From: Andy Young [REDACTED]
Sent: 12 August 2020 15:55
To: Sian Eggington: [REDACTED]
Cc: [REDACTED]
Subject: M/59/20/HH - 56 Southdean Drive, Middleton
Attachments: [REDACTED]

Further to the request received this afternoon, please see attached updated site and floor plans included the following :

DWG NO. **205 / 3.001**

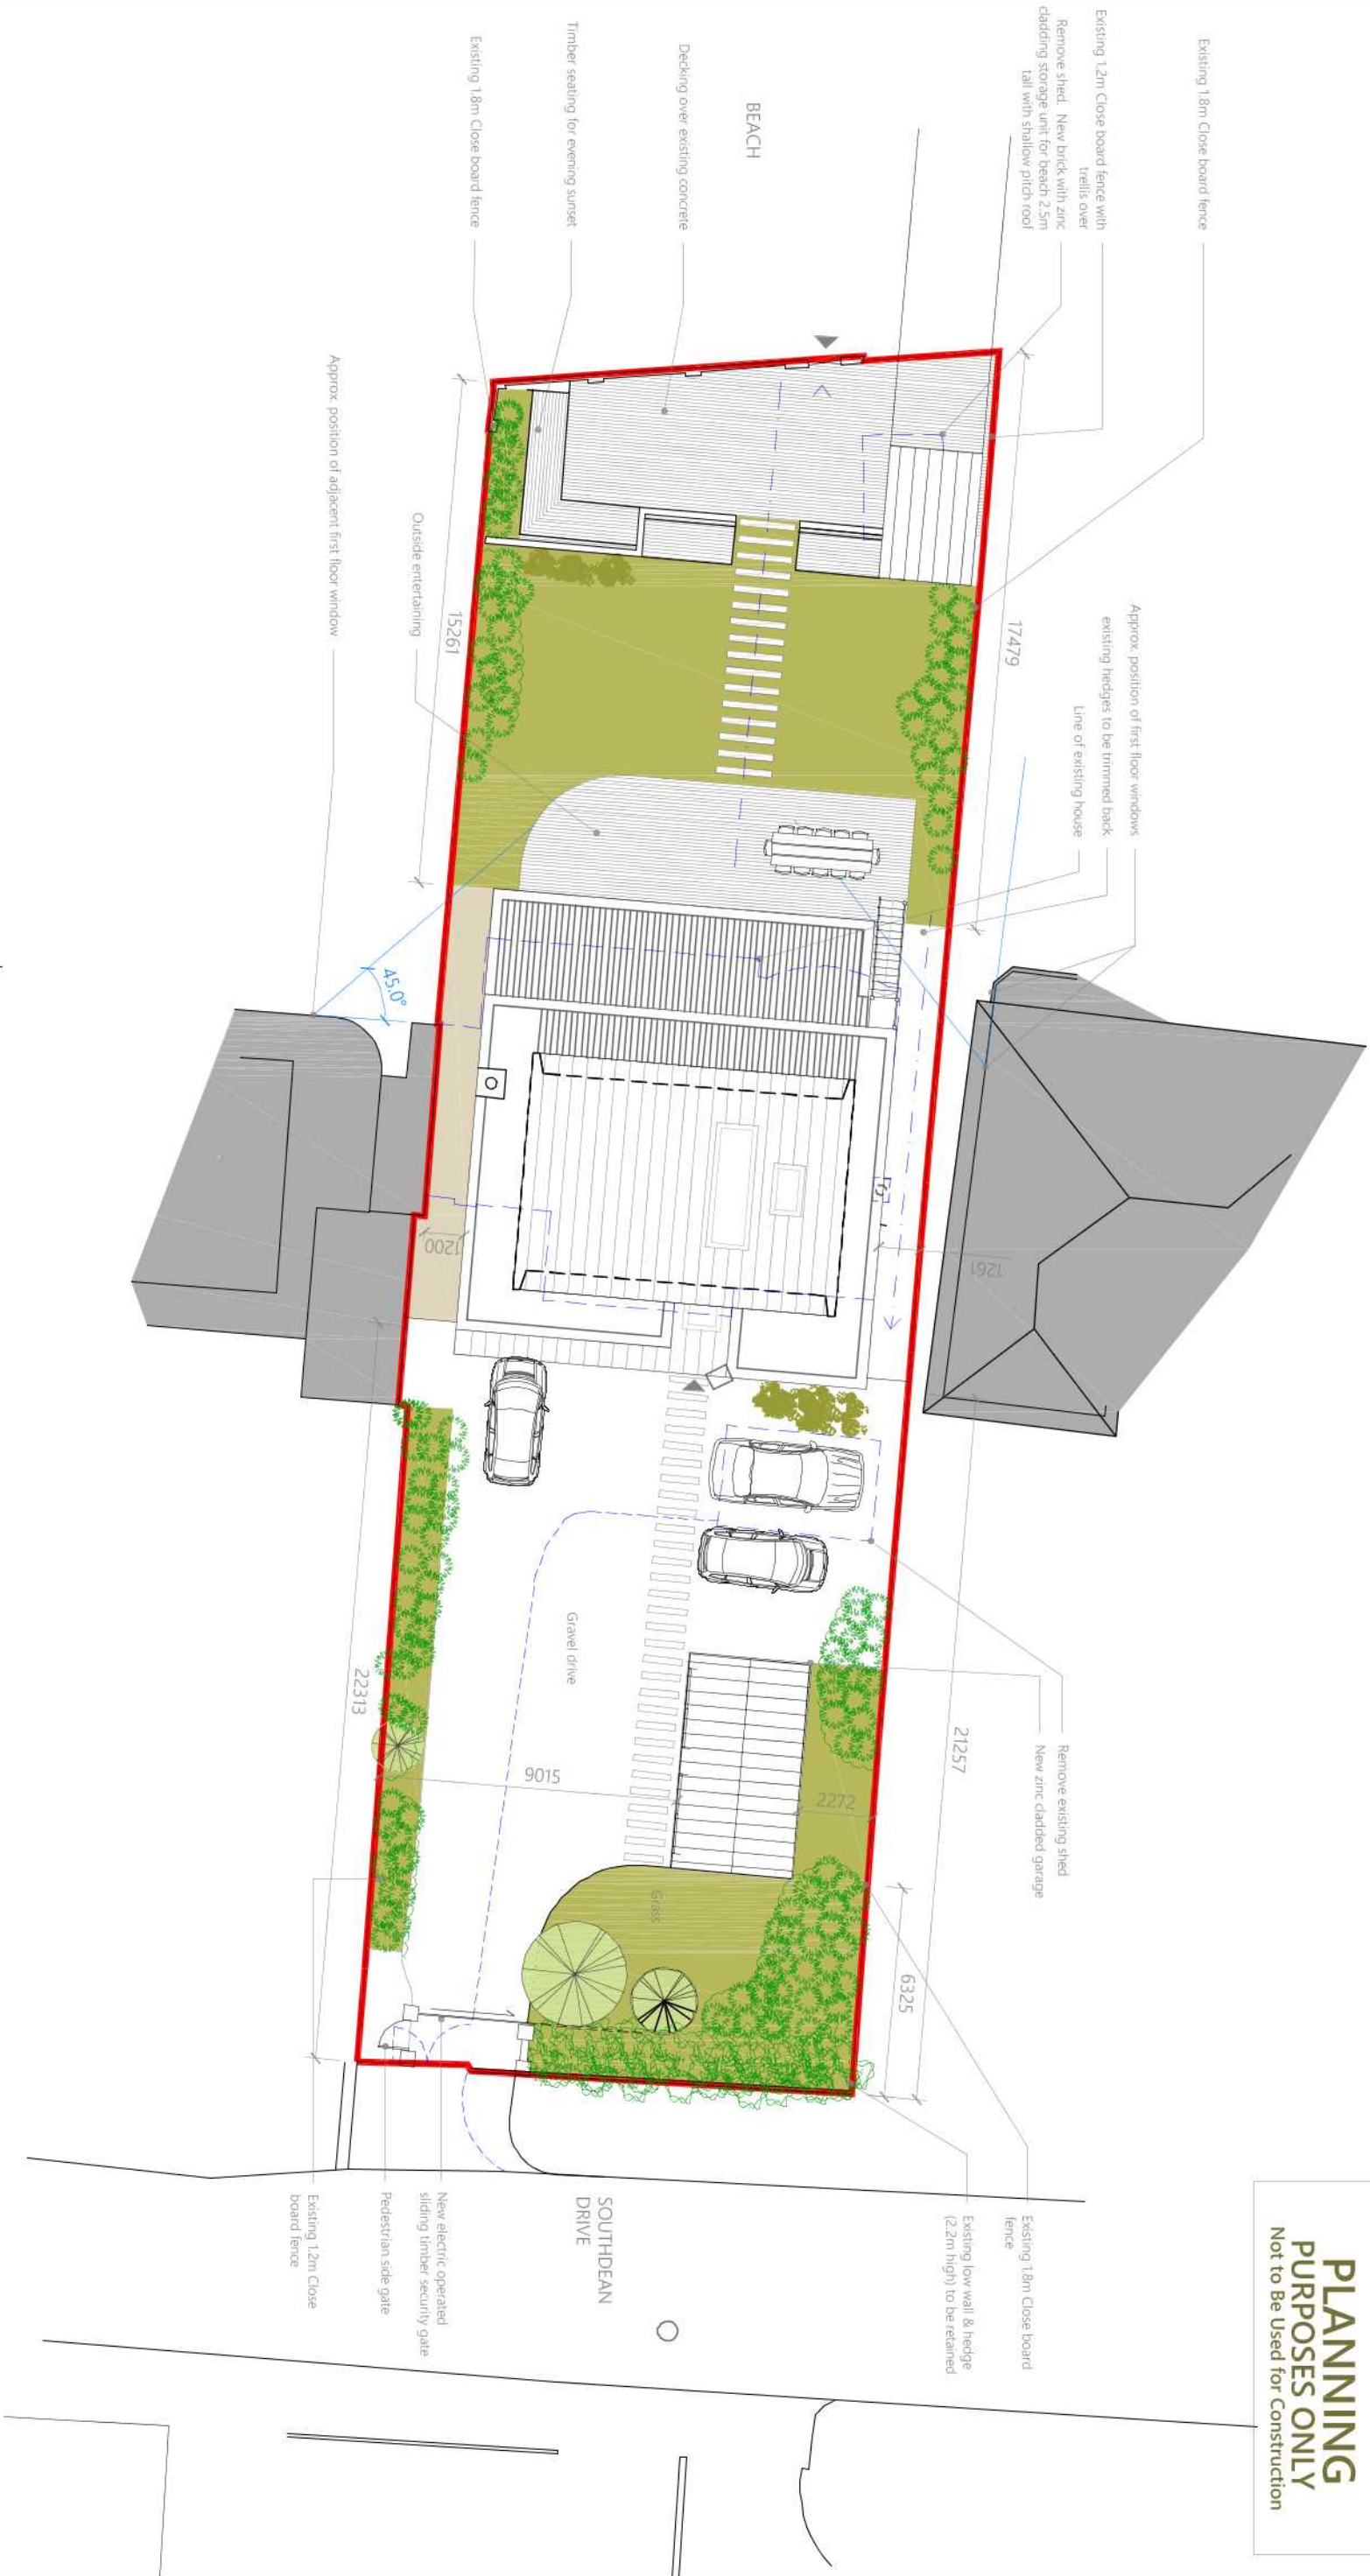
- include dimensions from the proposed extension to all site boundaries – These are now shown on RDG Dwg No. 3.001 (Rev 02) and 3.104 (Rev 02)
- [REDACTED]
- CIL Additional Information Form – attached. This isn't the first time that we've uploaded CIL forms through Planning Portal and they haven't been received – perhaps if you find this a frequent issue there may be a problem with the system?
